Historic England

26 April 2021

**BROOKES MILL, ARMITAGE ROAD, ARMITAGE BRIDGE, HUDDERSFIELD, HD4
7NR**

Application Nos 2021/90585 & 2021/90584

Building 29 Existing Elevations & Sections

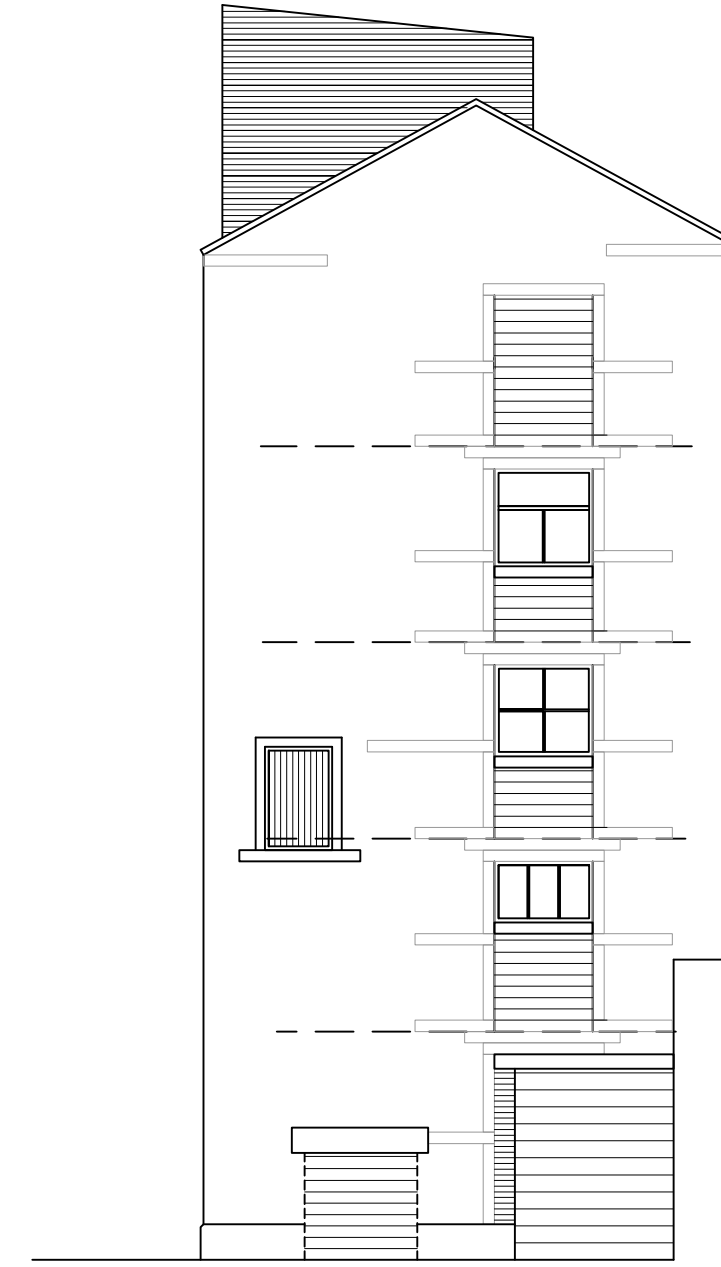
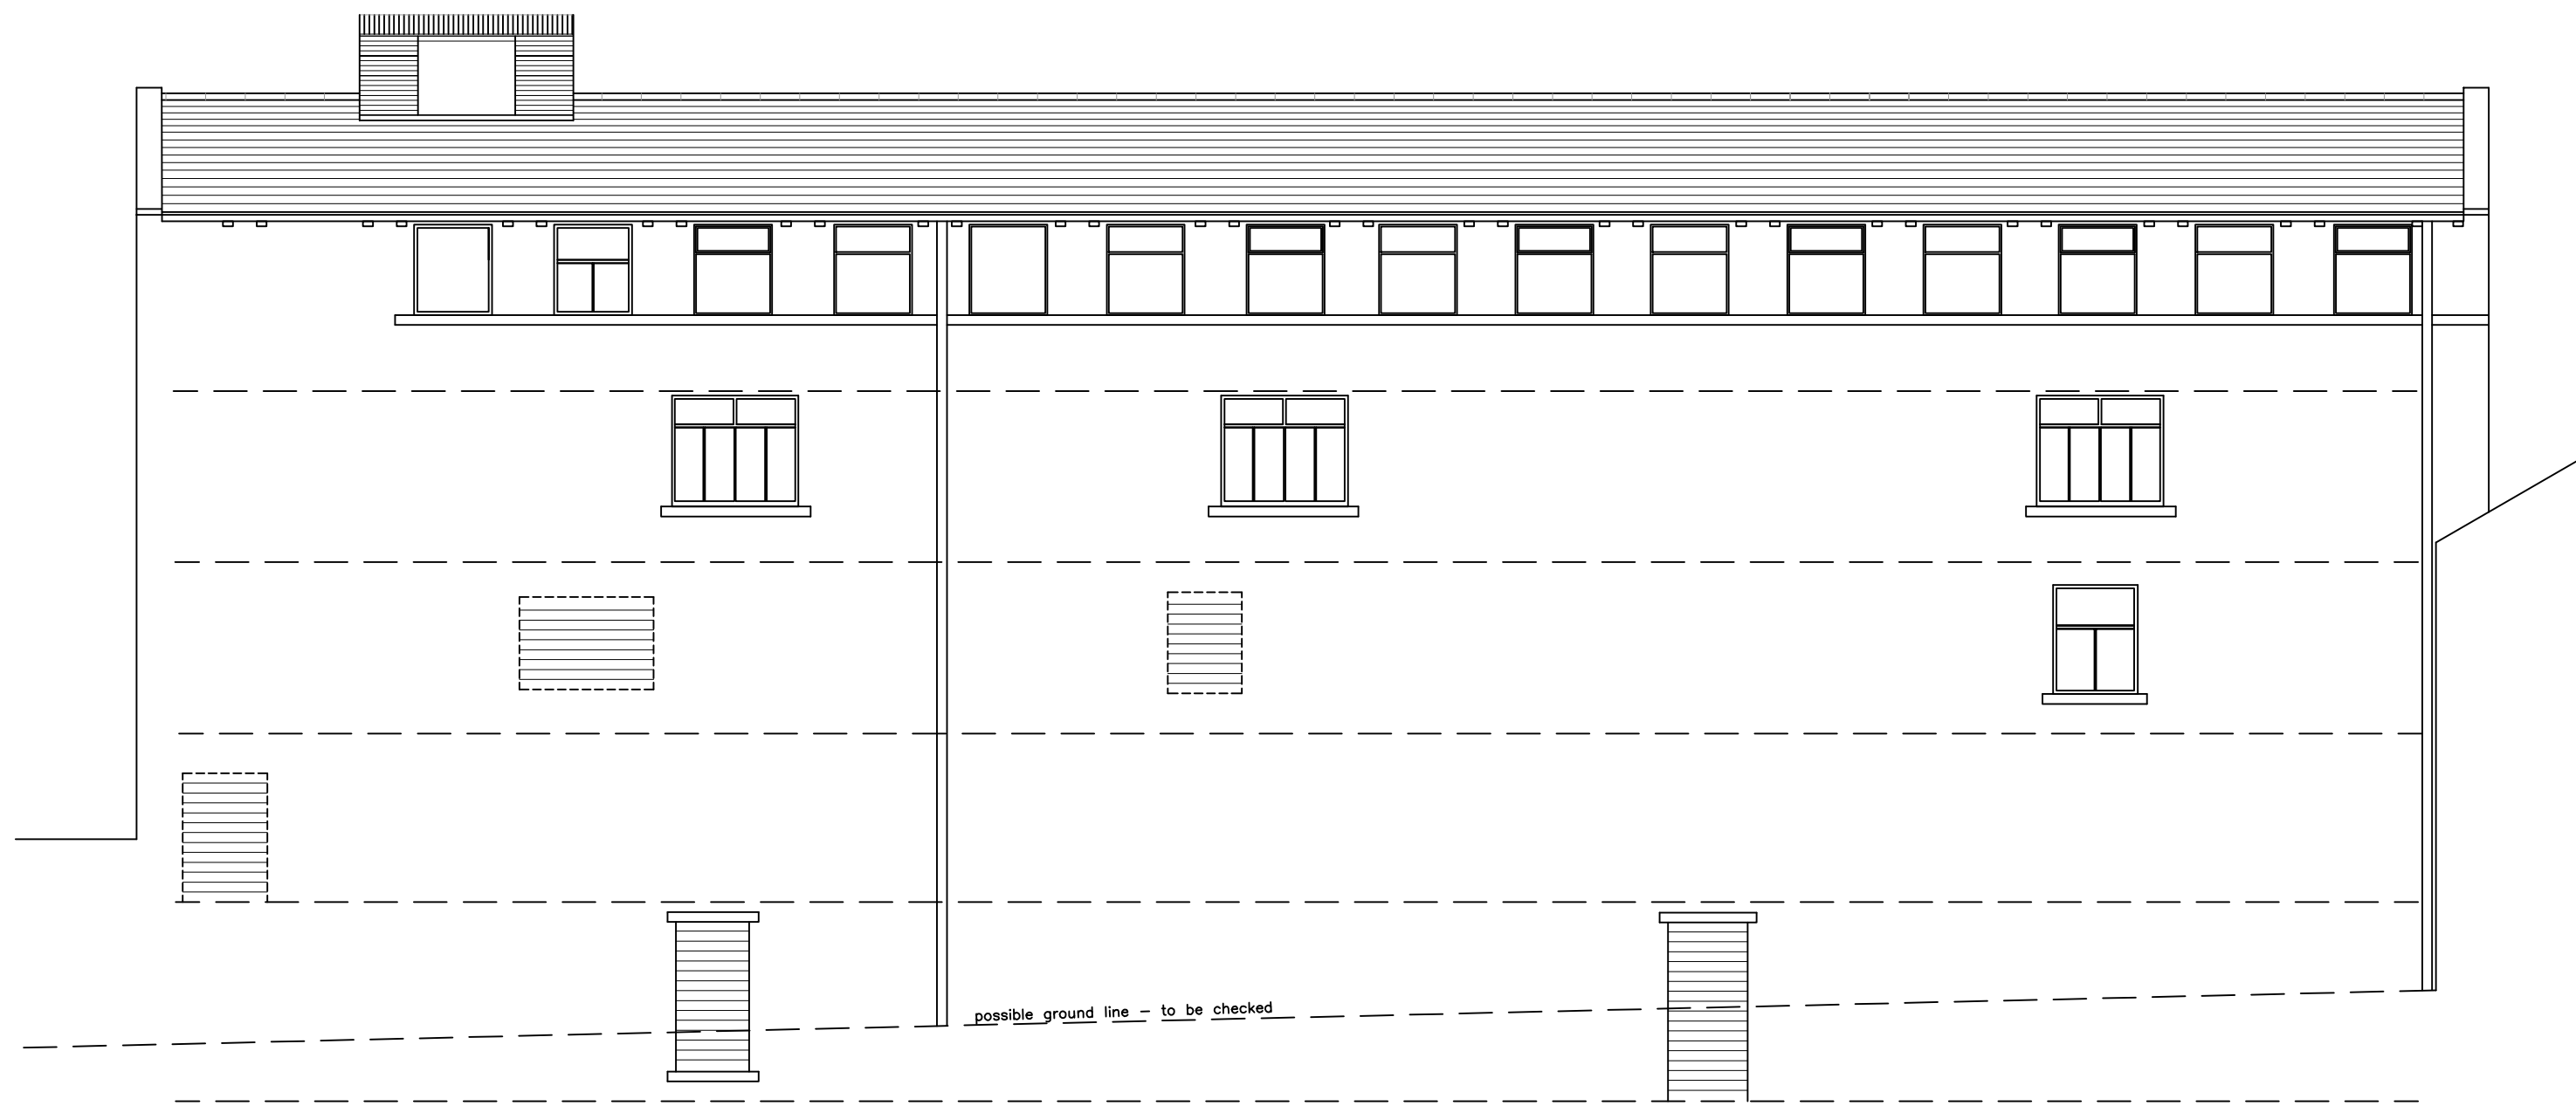
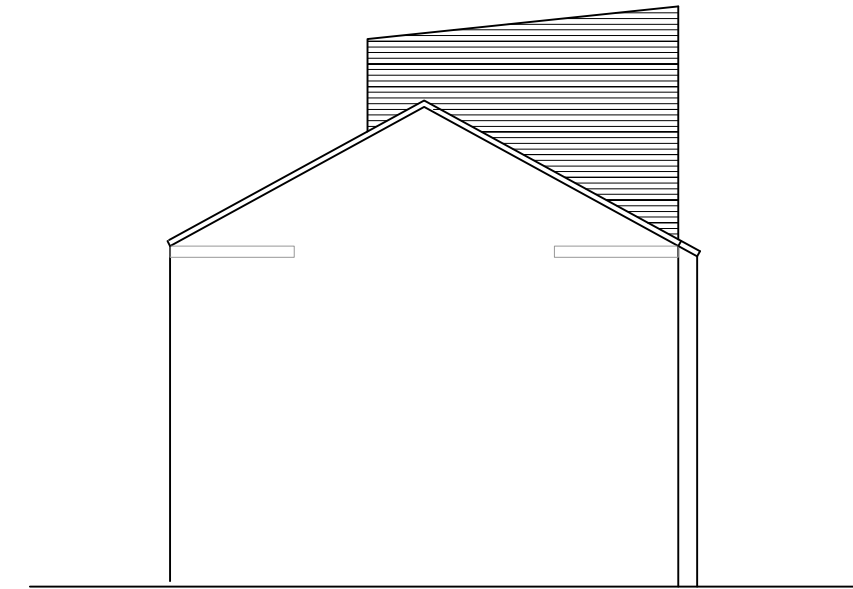
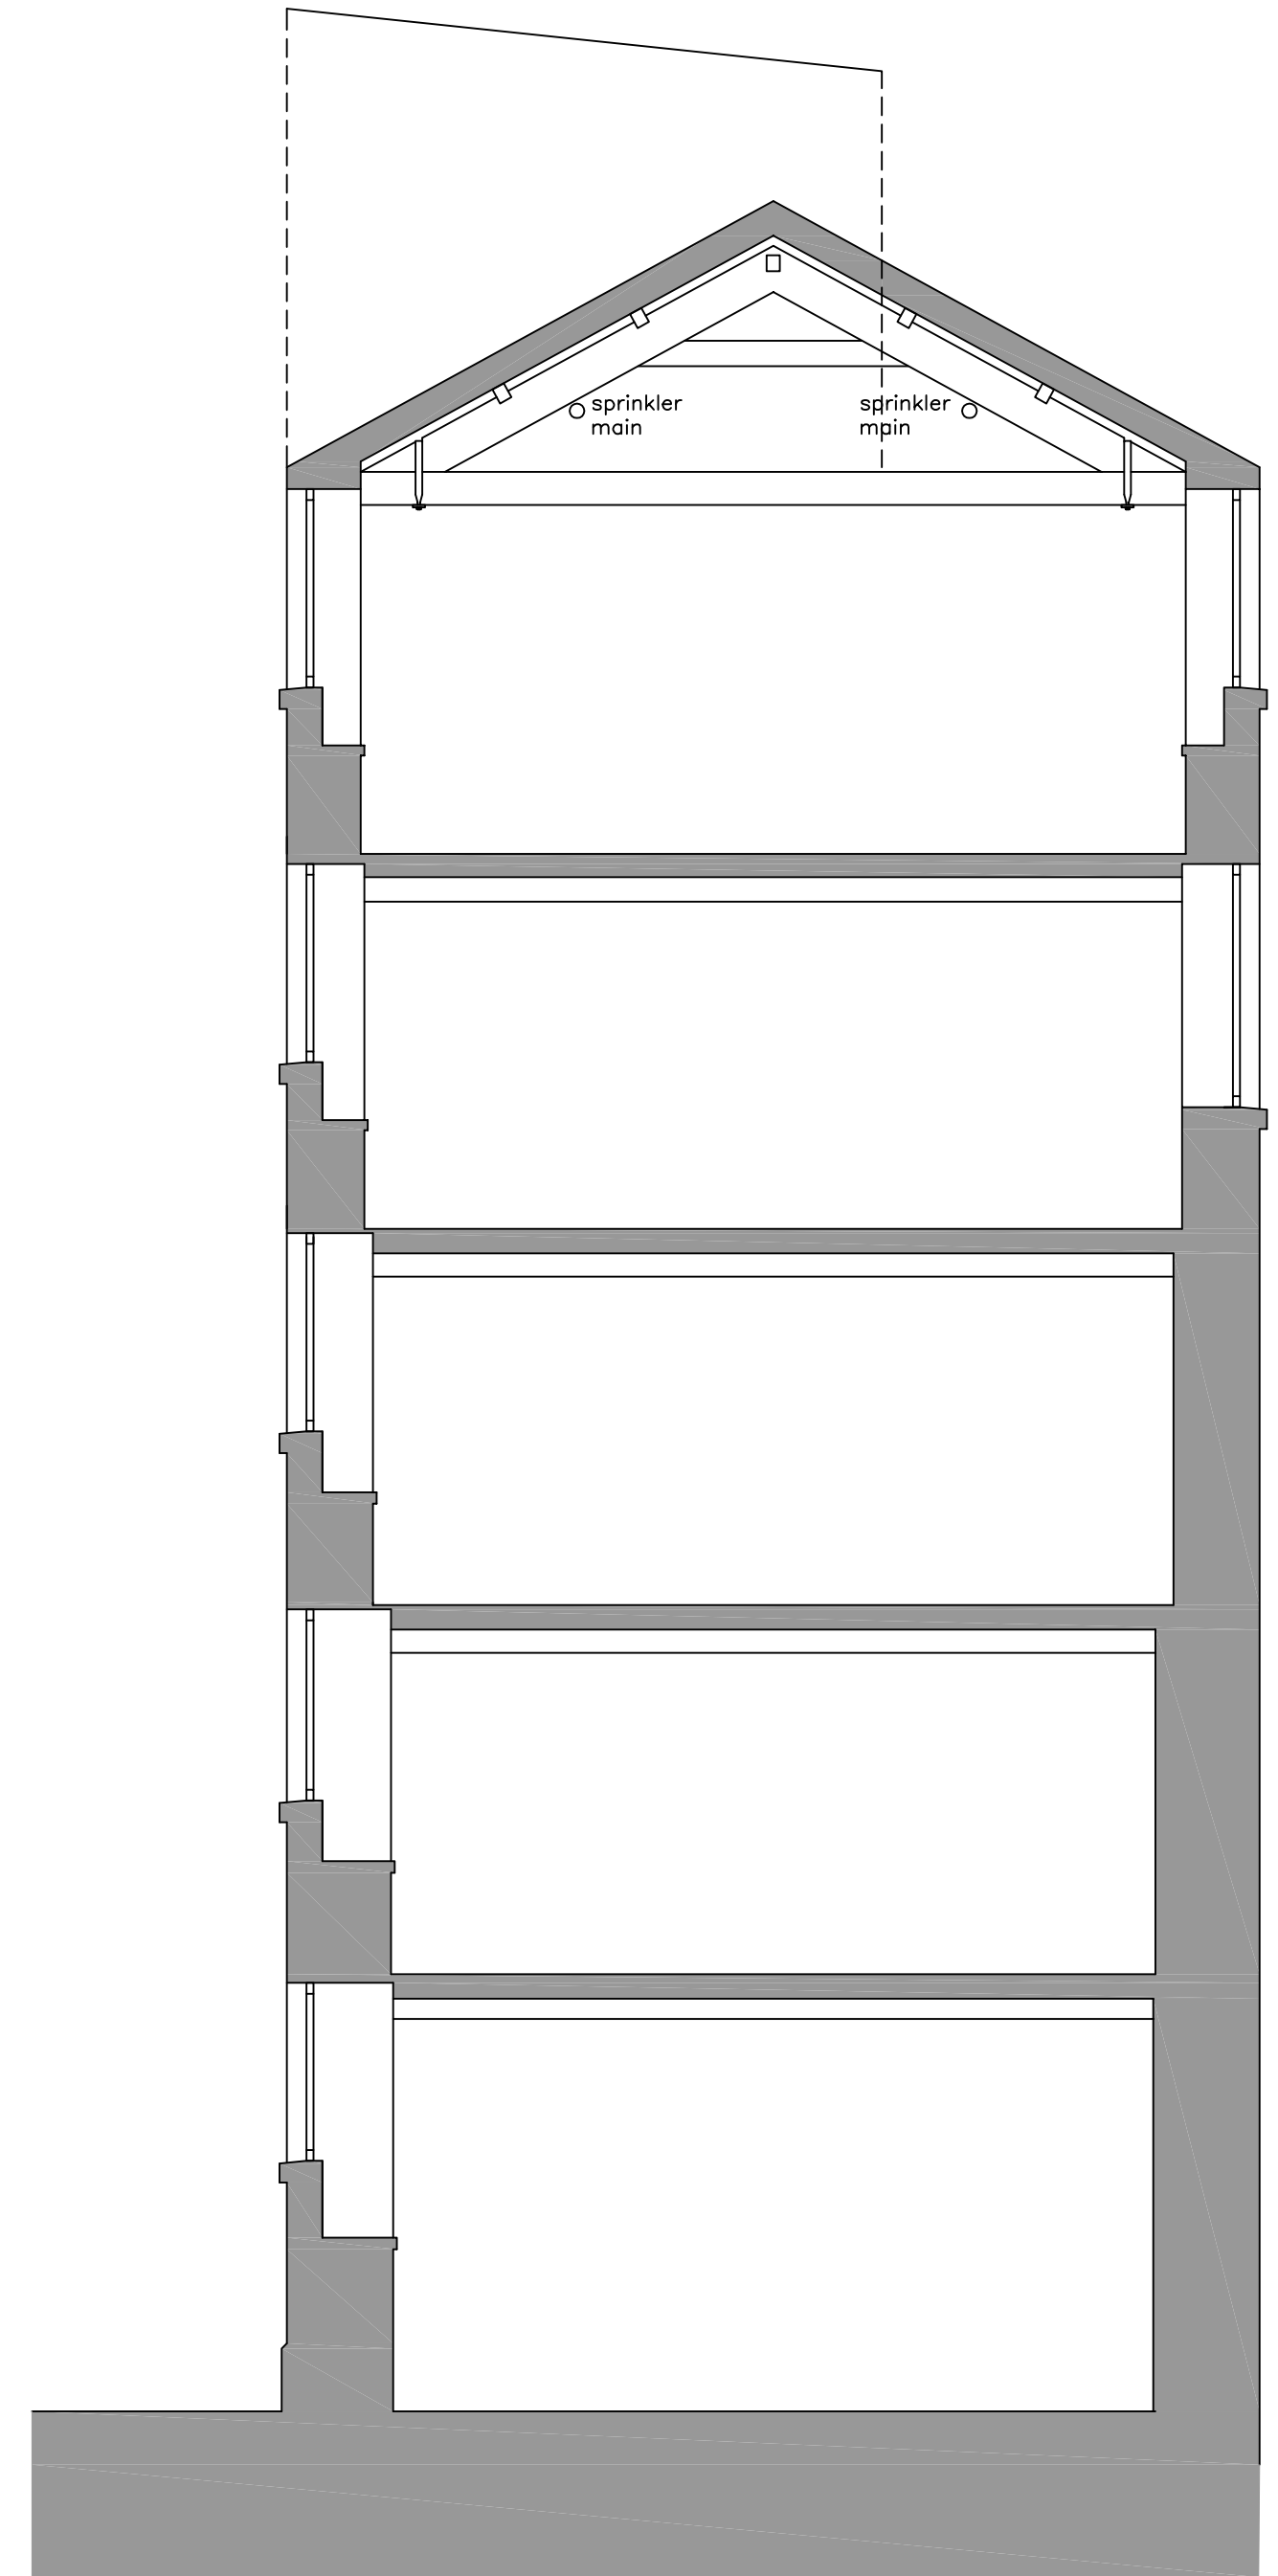
Building 29 - the former loom shop - is one of the earliest buildings within the site and contributes to the narrative of the development of the mill on its transition from hand power to mechanisation. Its form and scale make a positive contribution to the setting of the grade II listed tower, giving context and a sense of enclosure and being a prominent building in views from the recently created courtyard.

The structural report submitted with this application describes the poor condition of the floors and the substantial reinforcement of the timber structure required for the building to be capable of re-use. The lack of horizontal restraint has led to problems of structural instability on the upper levels, which are exacerbated by the building's length and height. The case presented is that the costs of restoring and strengthening the upper three storeys do not add any significant return required for commercial viability.
